**WEST SUSSEX COUNTY COUNCIL
STRATEGIC PLANNING CONSULTATION**

DATE: 26th August 2015

SUBJECT: Premier Inn – Spinney and Burberry House

Roundstone Lane/ Roundstone Road, East Preston, Angmering, BN16 1EB

3789/P2 D

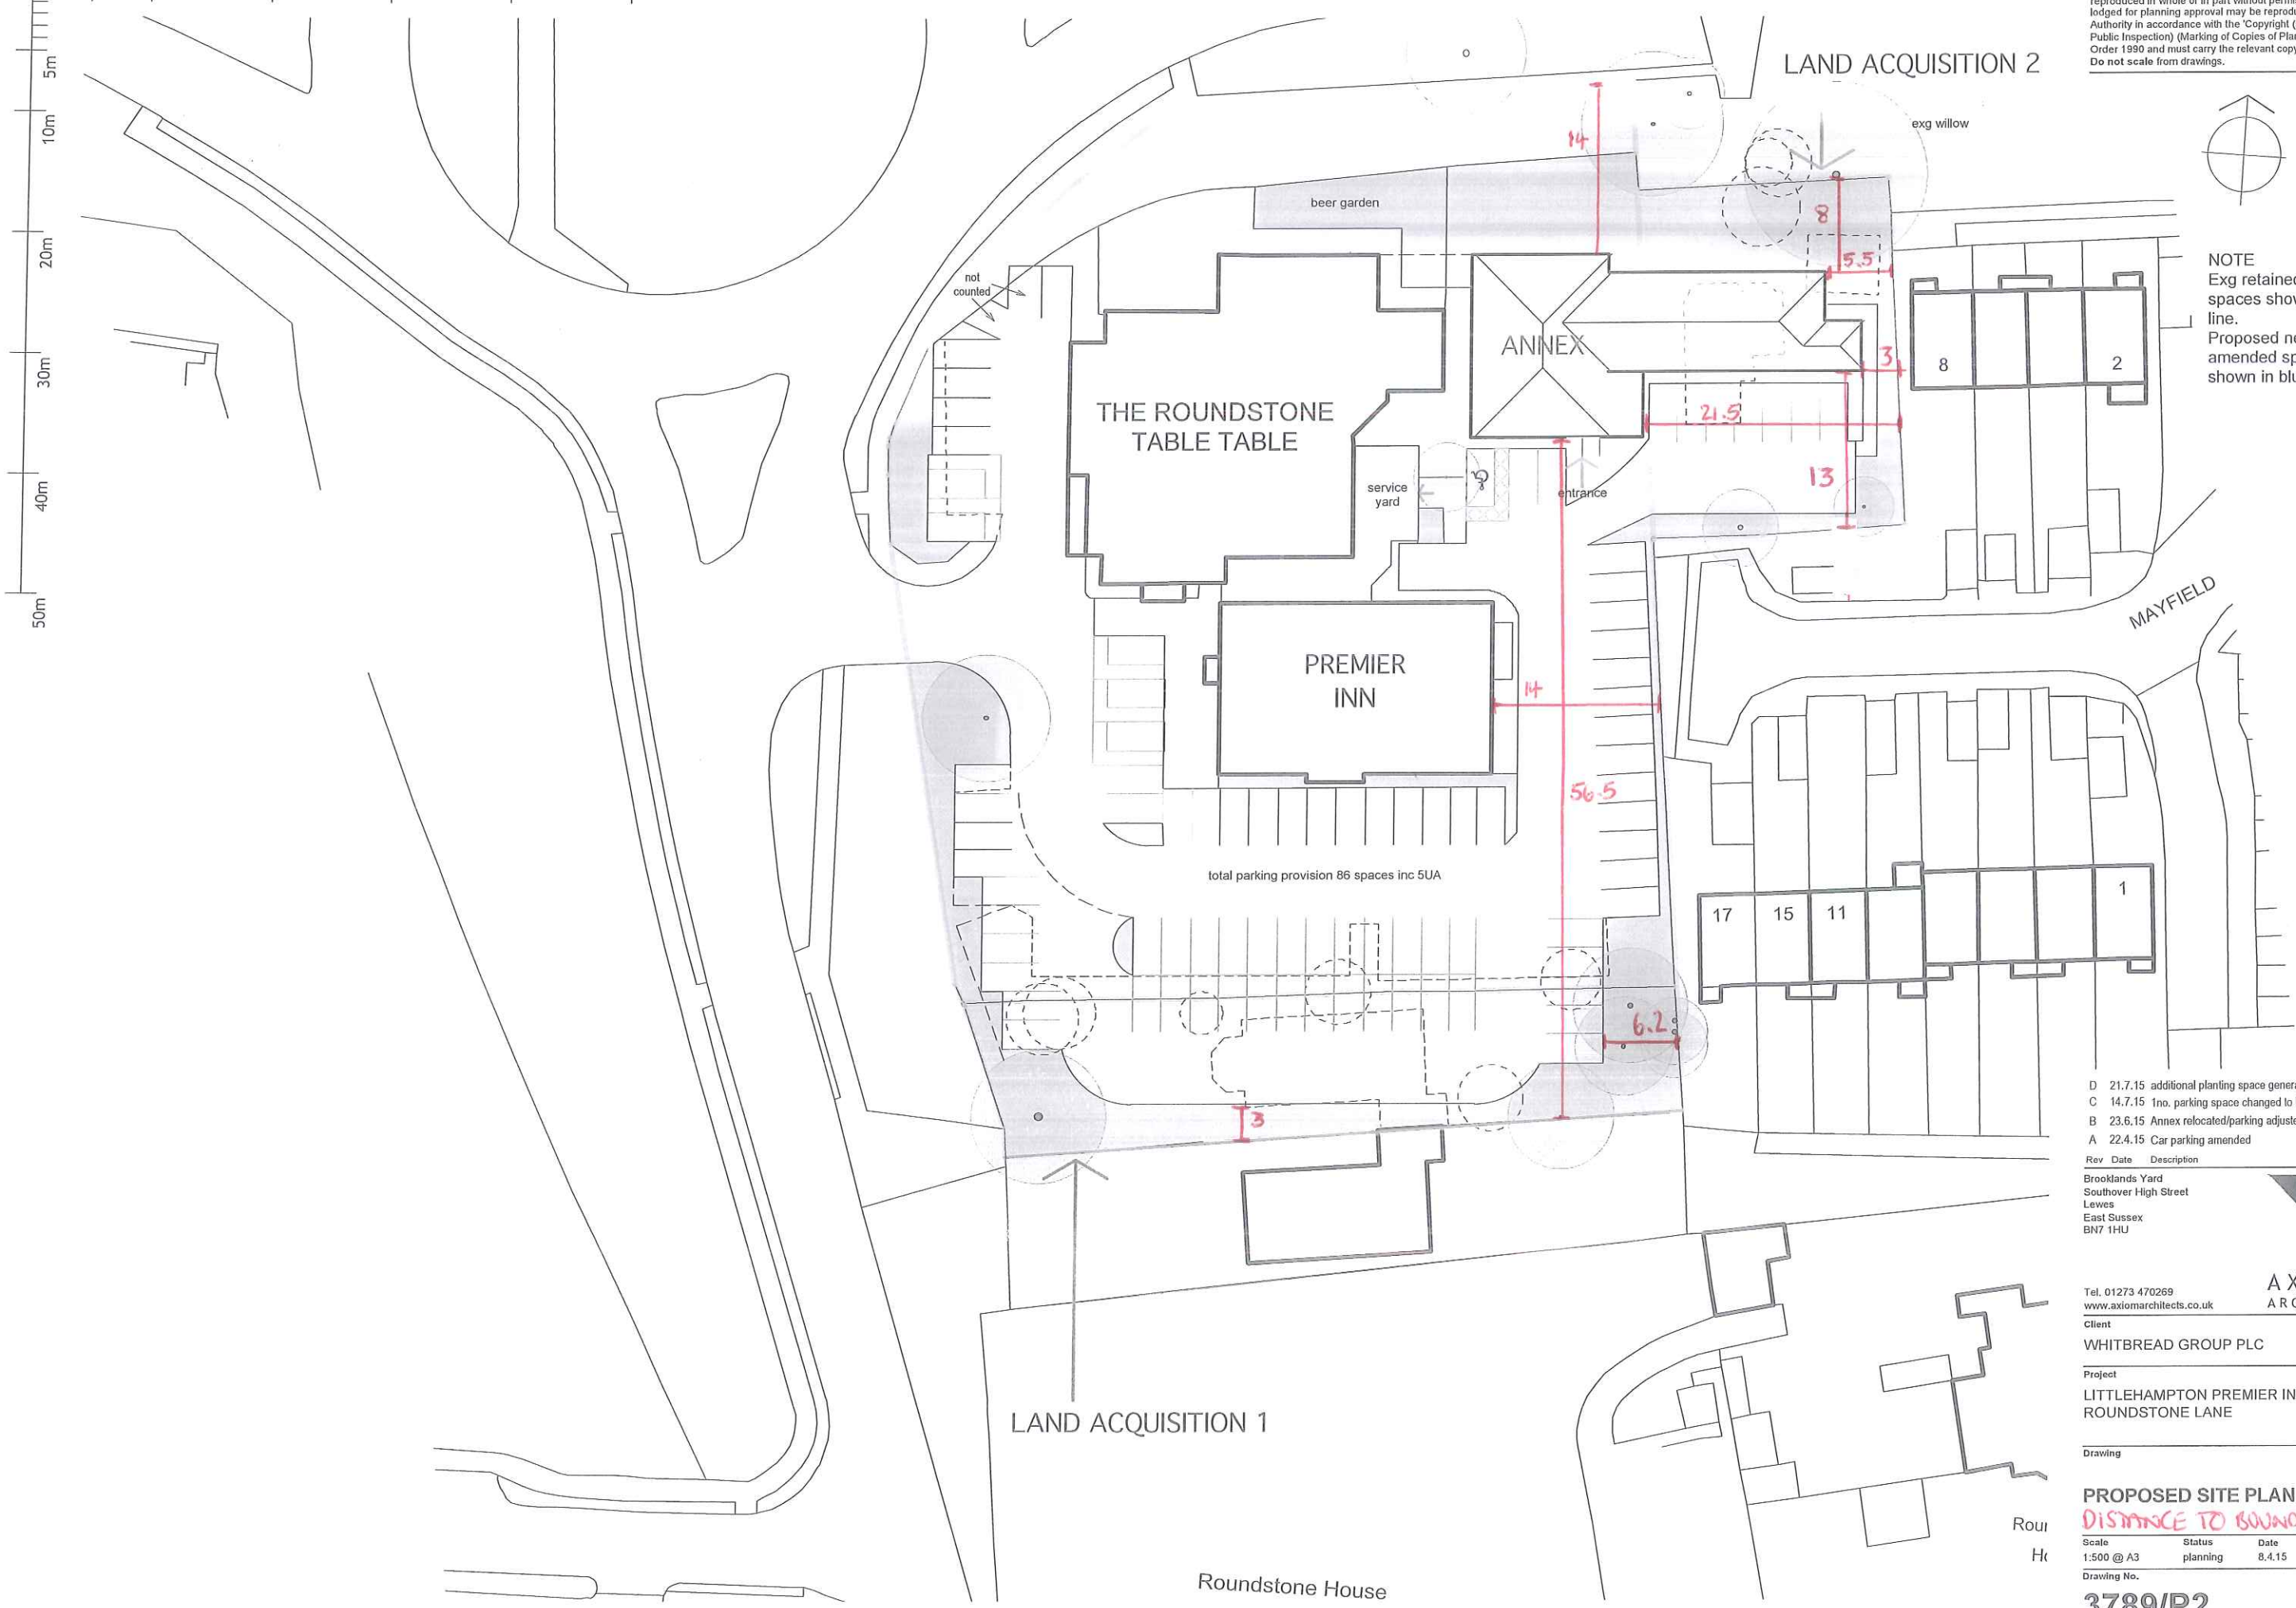
Land for the new annexe building and additional car parking has been acquired by demolishing the neighbouring properties of Spinney and Burberry. Both are residential properties with existing access points onto the highway network. Spinneys access is shared with another property and will remain in use however; Burberrys access onto the A529 Roundstone Road will need to be closed. This can be controlled via a suitably worded planning condition, and progressed via the S278 process.

The site will provide additional parking. This has been checked and is in line with WSCC car parking standards for restaurants and hotels. The standards indicate that for the size and type of development, 1 space per bedroom and 1 space per table should be adopted. This would equate to 40 spaces for the bedrooms and 44 spaces for the restaurant, creating a total of 84 spaces. The proposals indicate the site will be able to offer 92 car parking spaces, well within the maximum standards recommended. Indeed, the supporting parking surveys show that it is unlikely the car park will ever reach full capacity. This is due to the complimentary nature of both businesses whereby the car park can be used at different times of the day without conflict. The parking surveys show that at its busiest the car park was only 55% occupied.

Cycle parking, which is covered and secure, will need to be provided in line with WSCC cycle parking guidance for half a space per bedroom or similar to what has been implemented at other Premier Inn locations.

Details of the demolition/construction phase of the development have not been submitted and will need to include details as per the recommended condition below. In particular WSCC would consider keeping the works traffic and customer traffic separate for the duration of the build, and this must be submitted prior to any commencement of building works. The use of the existing access on the A259 as a temporary works access would achieve this and this could be closed and re-instated to grass verge once the build is complete.

No part of the development shall be first occupied until such time as the existing vehicular access onto A259 Roundstone Road has been physically closed in accordance with plans and details submitted to and approved in writing by the Local Planning Authority.

No part of the development shall be first occupied until the car parking spaces have been constructed in accordance with plans and details submitted to and approved in writing by the Local Planning Authority. These spaces shall thereafter be retained at all times for their designated use.

No part of the development shall be first occupied until covered and secure cycle parking spaces have been provided in accordance with plans and details submitted to and approved by the Local Planning Authority.
